From: Anita Gardner
Sent: 26 July 2018 10:16
To: [REDACTED]
Subject: FW: Planning Consultation on LU/120/18/DOC and LU/155/18/DOC

This application is looking for the discharge of Condition 15 of application LU/120/18/DOC

Site Address: Directors Cottage Toddington Lane
Littlehampton BN17 7PP

Description of Works: Approval of details reserved by condition imposed under LU/249/17/PL relating to conditions 3-Construction Management Plan, 5-visibility splays, 15- landscape scheme & 16-schedule of materials & finishes.

Site of Sunnymead, Courtwick Lane, Littlehampton:
Proposed Terrace of three new Houses and new Detached House by Ware Builders Ltd - HARD and SOFT LANDSCAPING

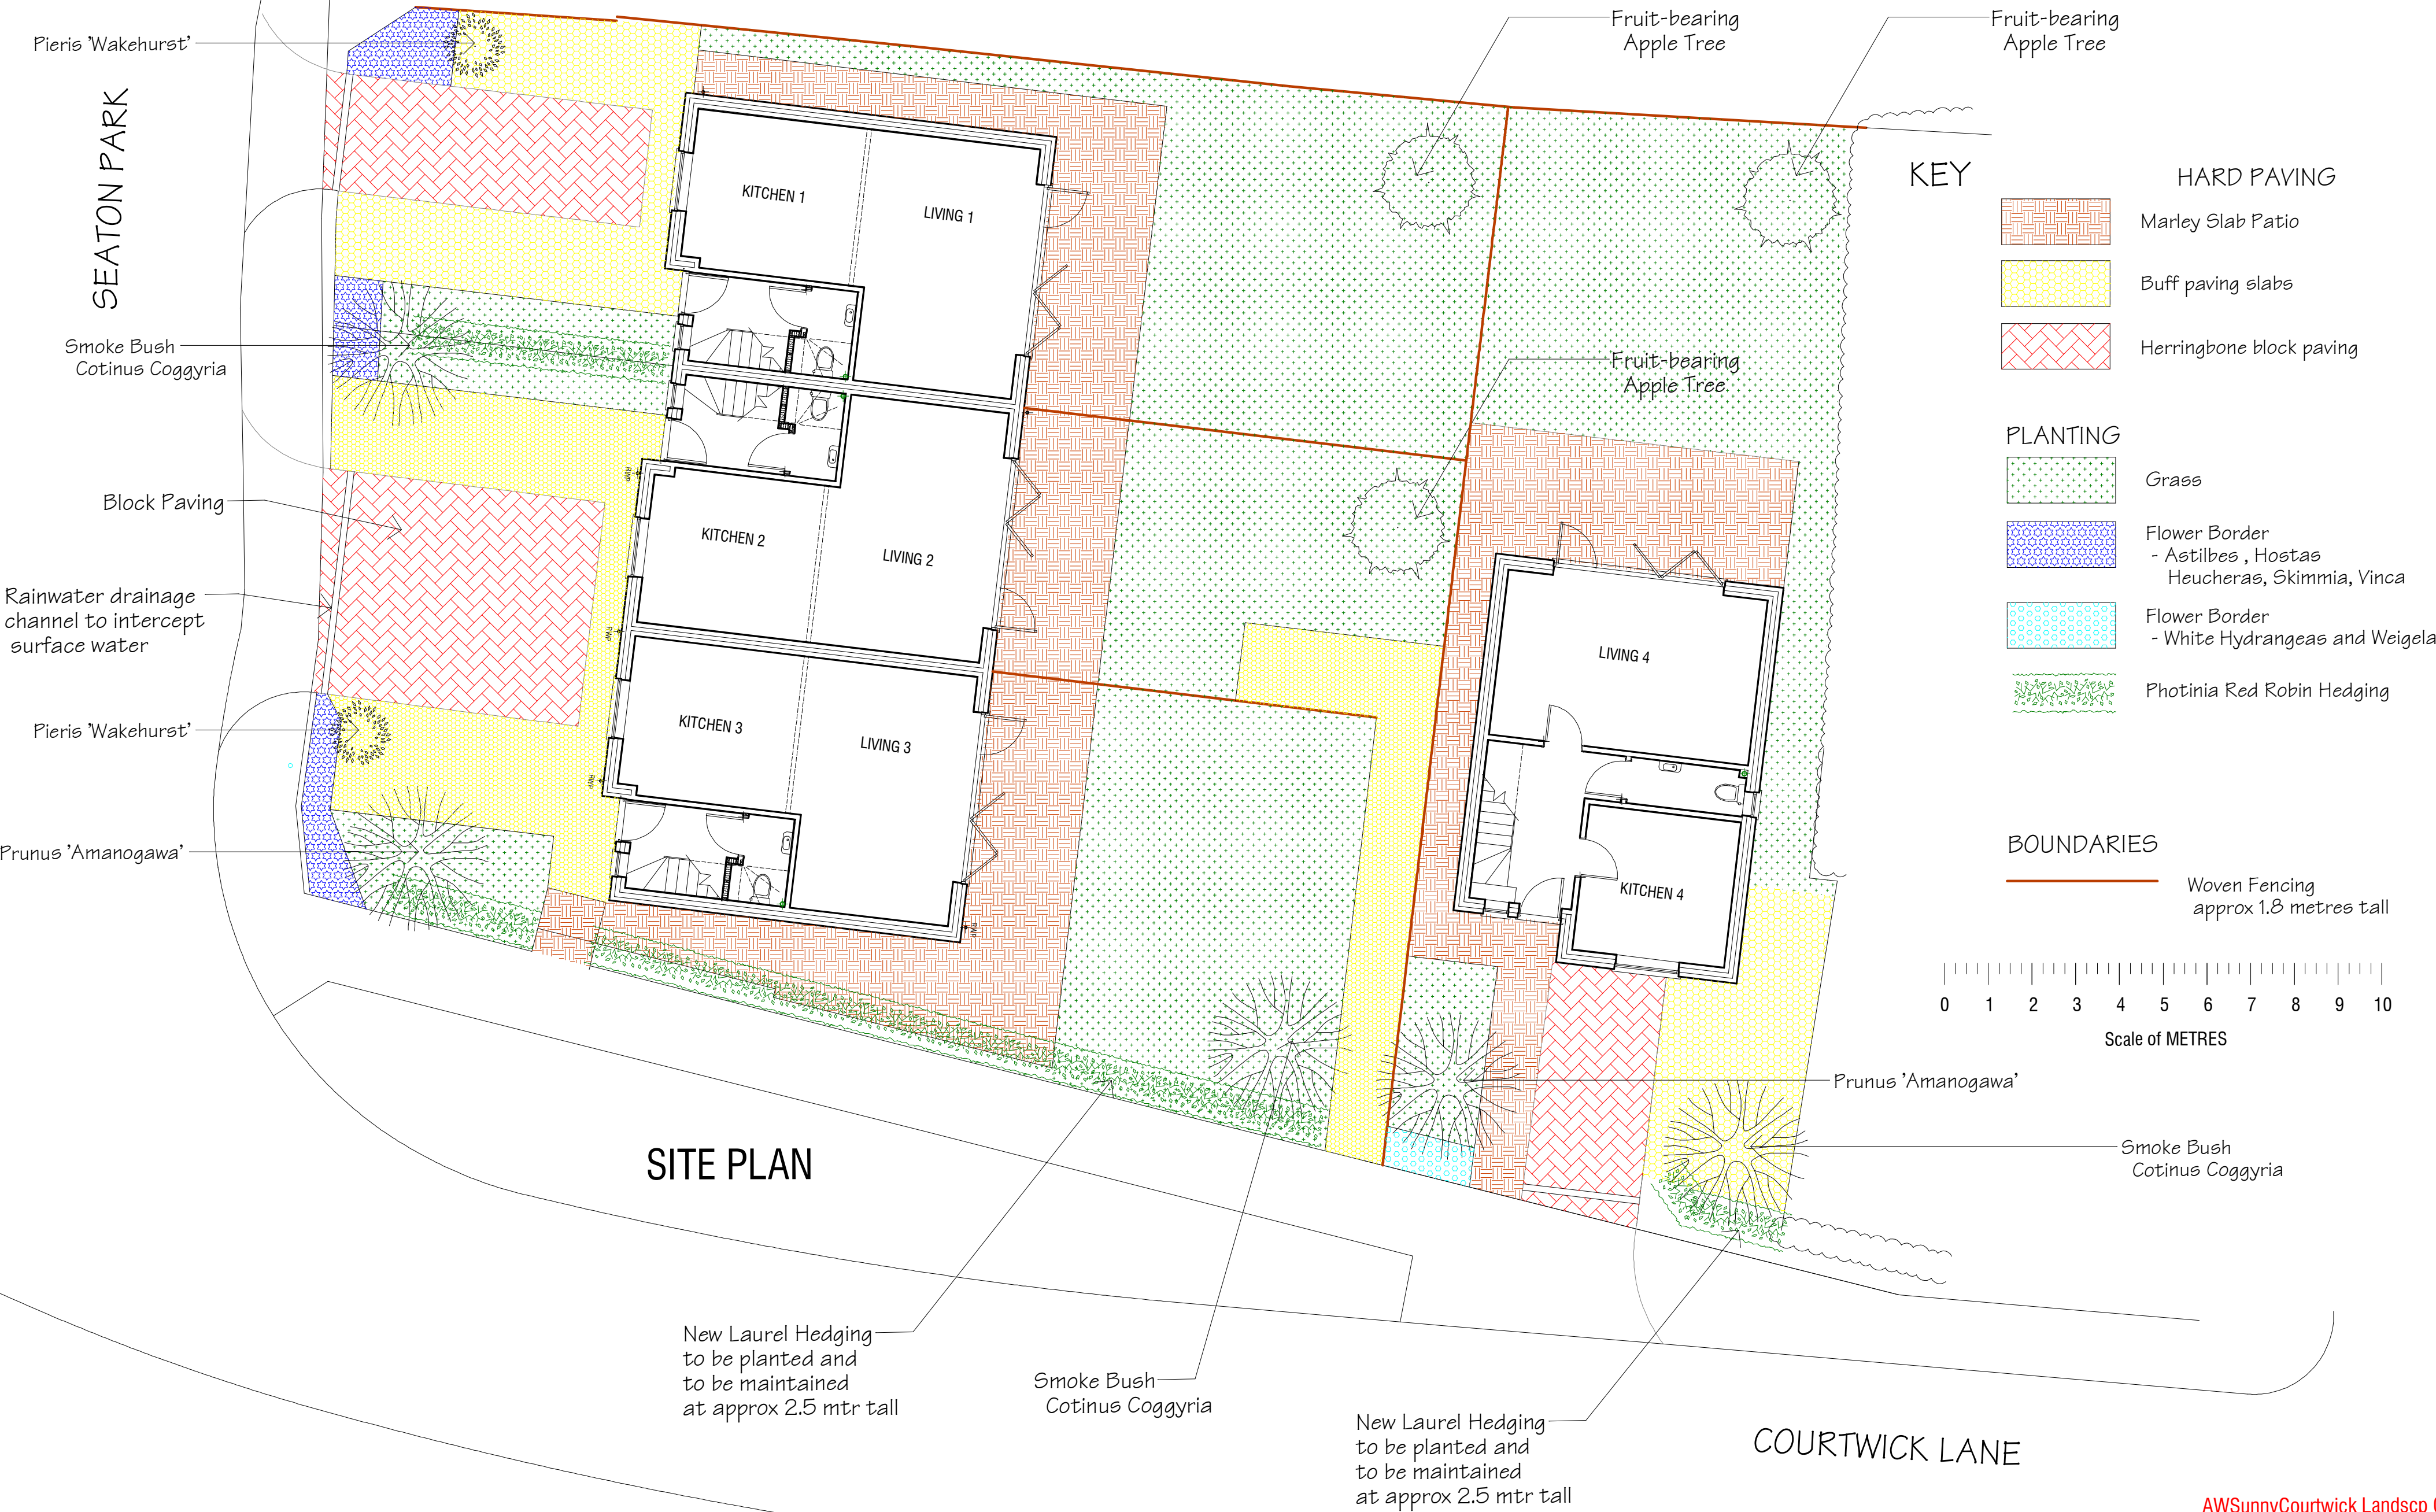
This application lists Condition 15 however no further details have been submitted re Landscape scheme and the information contained within DWG 17/4430/05 and 17/4430/16 is insufficient in detail as not providing detail in plan form of proposed trees and shrubs detailing actual quantities, species choice planting density and size at time of planting. As my previous comments, greening of new development is required to ensure that the development is fitting to location, aiding in good design, providing screening to adjacent dwellings where required and encouraging biodiversity within the site.

There is insufficient information submitted and therefore I would **not recommend the discharge of Condition 15** on application LU/120/18/DOC imposed under LU/249/17/PL until further detail is submitted for approval.
